CITY OF PORTLAND
 FIRE PREVENTION BUREAU
 380 Congress Street, Portland, Maine 04101
 fireprevention@portlandmaine.gov
 (207) 874-8400

NOTICE OF VIOLATION AND ORDER TO CORRECT

May 4, 2017

Responsible Party 1: J & P LLC 250 HIGH ST PORTLAND, ME 04101		
Location 250 HIGH ST	CBL 036 D021001	Inspection Date 4/19/2017
Inspector Daniel Thompson	Inspection Type FP Routine Inspection	Status Failed

A-2 250-252 High St.

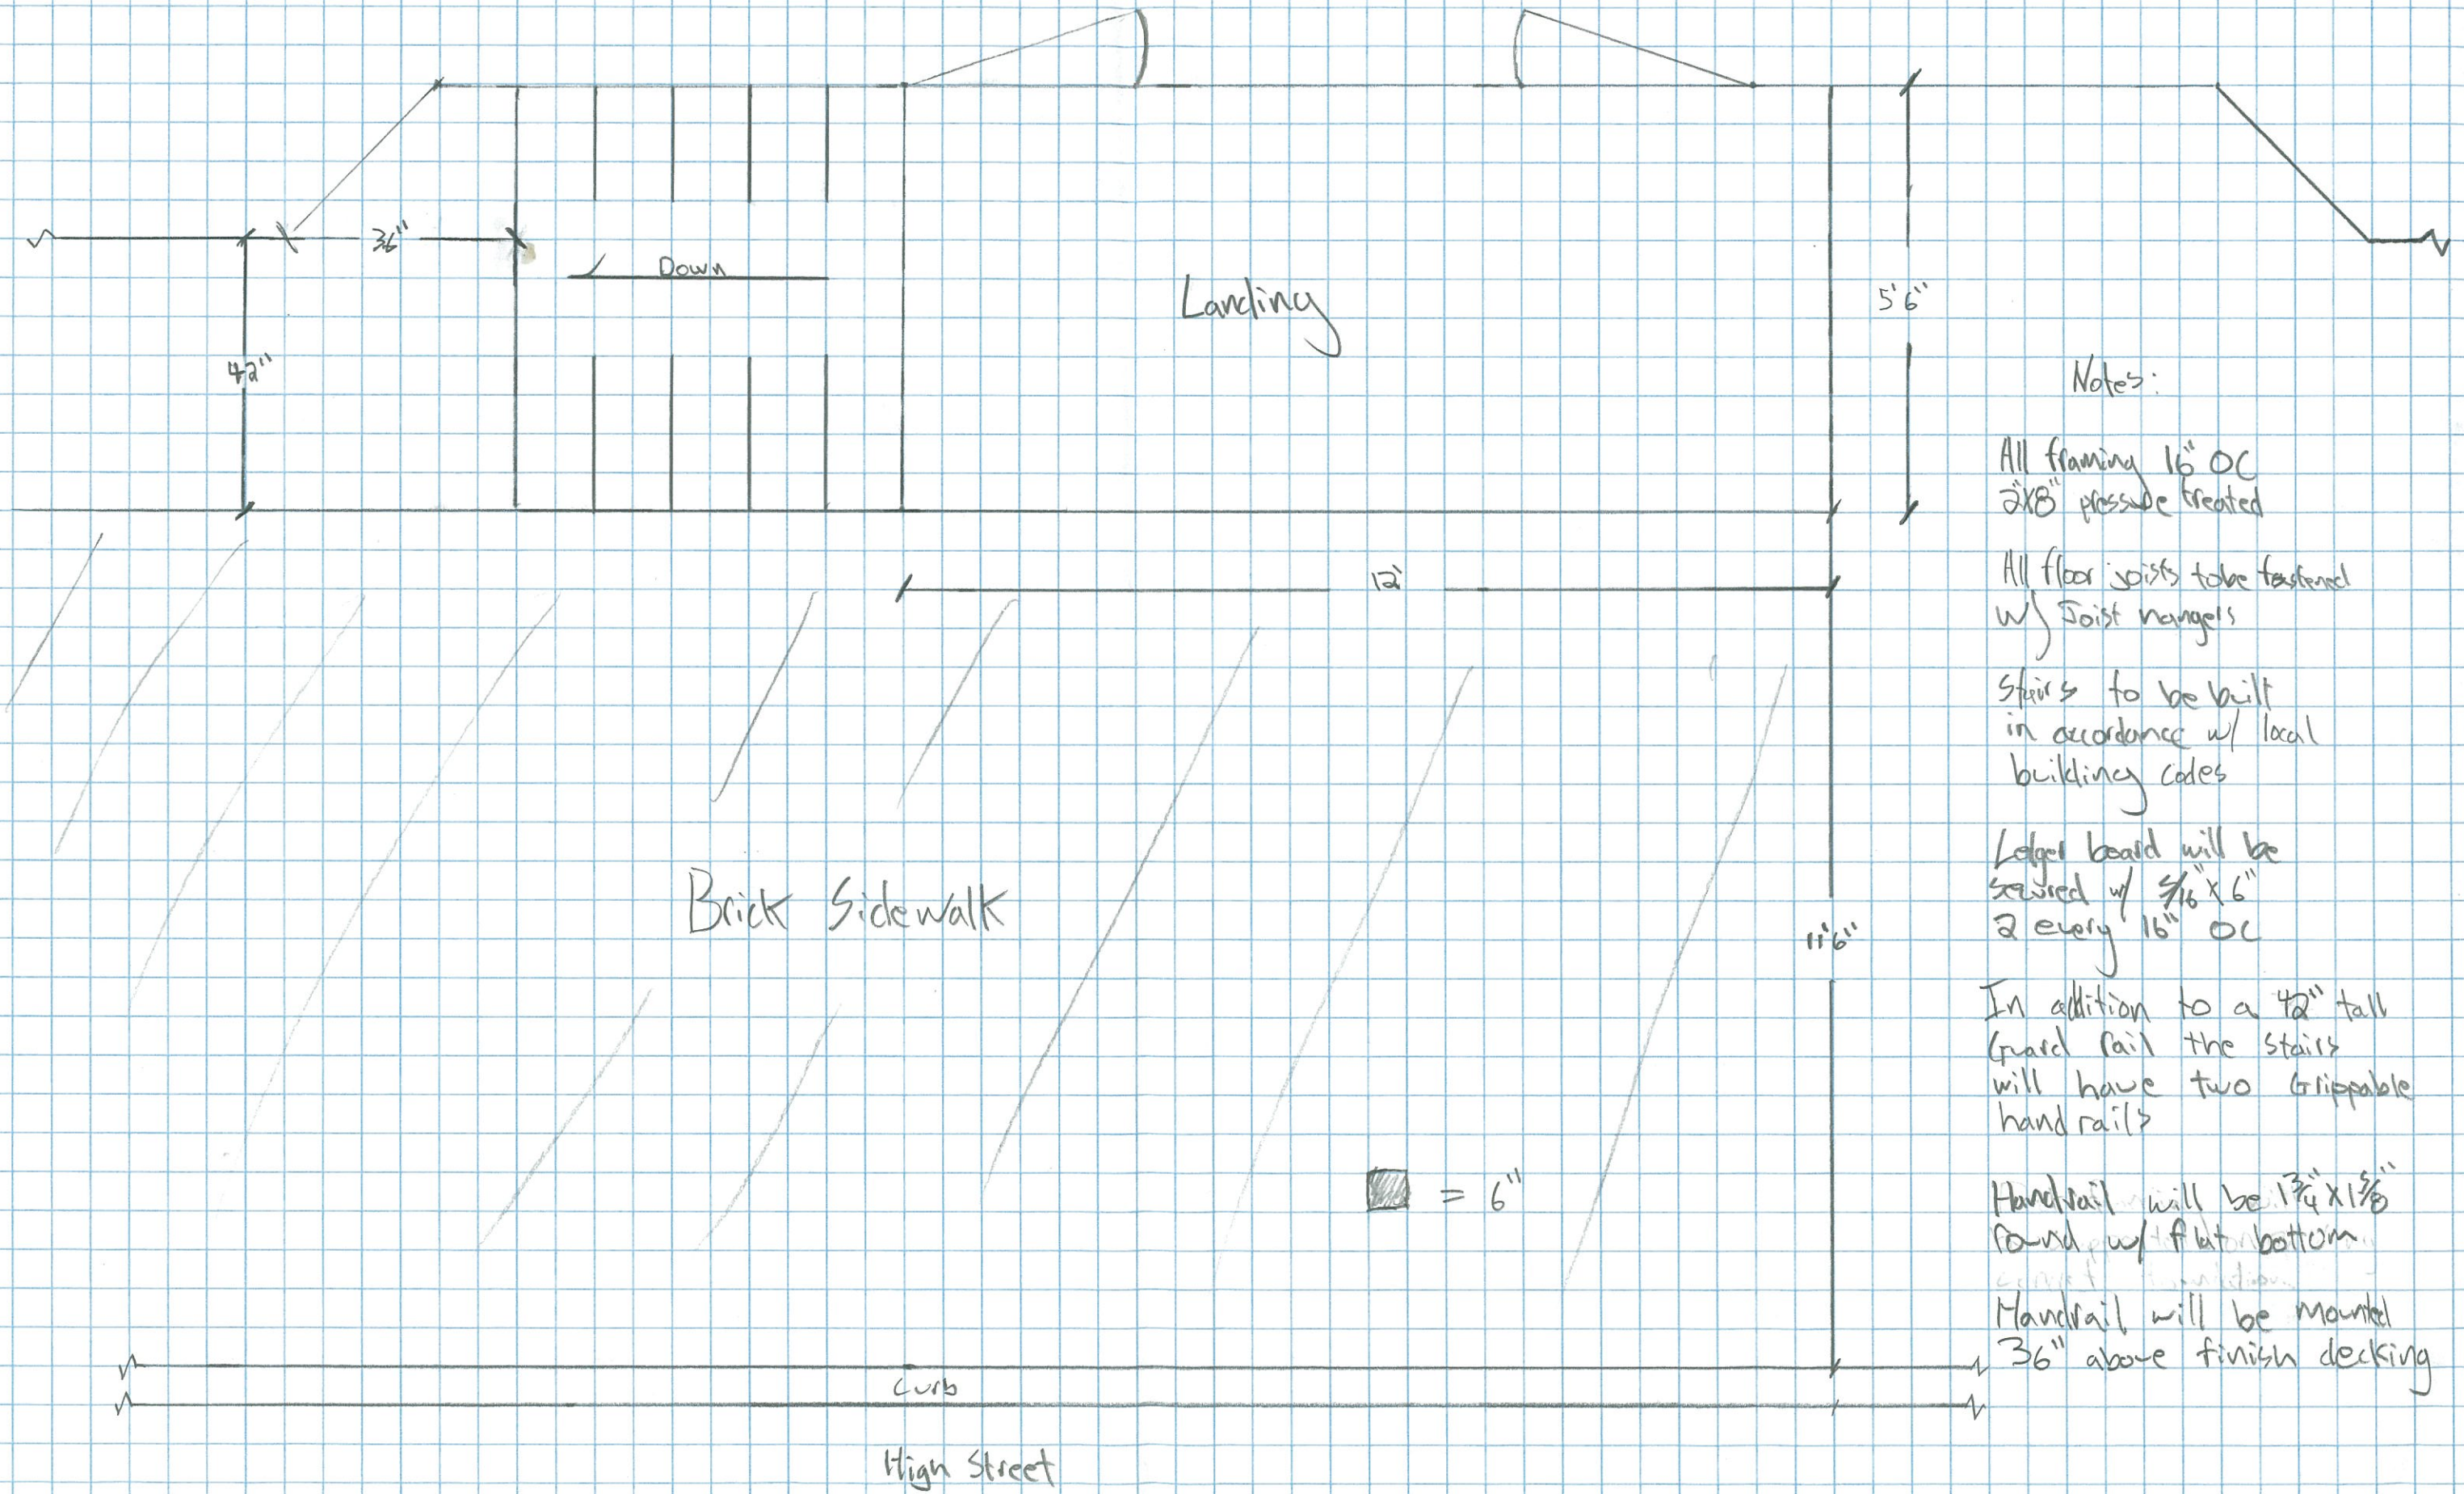
Violation	Proposed Date of Completion
<p>NFPA 101- 7.5.1.1 EXIT OBSTRUCTED; Where exits are not immediately accessible from an open floor area, continuous passageways, aisles, or corridors leading directly to every exit shall be maintained and shall be arranged to provide access for each occupant to not less than two exits by separate ways of travel, unless otherwise provided in 7.5.1.1.3 and 7.5.1.1.4. front and rear stairwells used for storage, unused furniture blocking hallway</p>	<p>IMMEDIATELY remove all obstructions from the exits. Your signature below indicates that all obstructions have been removed and will not be replaced.</p>
<p>NFPA 101- 31.2.2.1.2 EXIT STAIR REQ 60-MIN FIRE DOORS - NON-HIGH-RISE; In buildings using Option 4, exit enclosures shall have a minimum 1-hour fire resistance rating, and doors shall have a minimum 1-hour fire protection rating.</p>	<p>___/___/___</p>
<p>NFPA 101- 7.2.2.1.1 STAIRS REQUIRE REPAIR; Stairs shall meet the following criteria: (1) New stairs shall be in accordance with Table 7.2.2.2.1.1(a) (2) Existing stairs shall be permitted to remain in use, provided that they meet the requirements for existing stairs shown in Table 7.2.2.2.1.1(b) (3) Approved existing stairs shall be permitted to be rebuilt in accordance with the following: (a) dimensional criteria of table 7.2.2.2.1.1(b) and other stair requirements of 7.2.2 (4) The requirements for new and existing stairs shall not apply to stairs located in industrial equipment access areas where otherwise provided in 40.2.5.2. third floor interior rear stairs are in disrepair, all exterior stairs are in need of repair (front and both sides)</p>	<p>___/___/___</p>
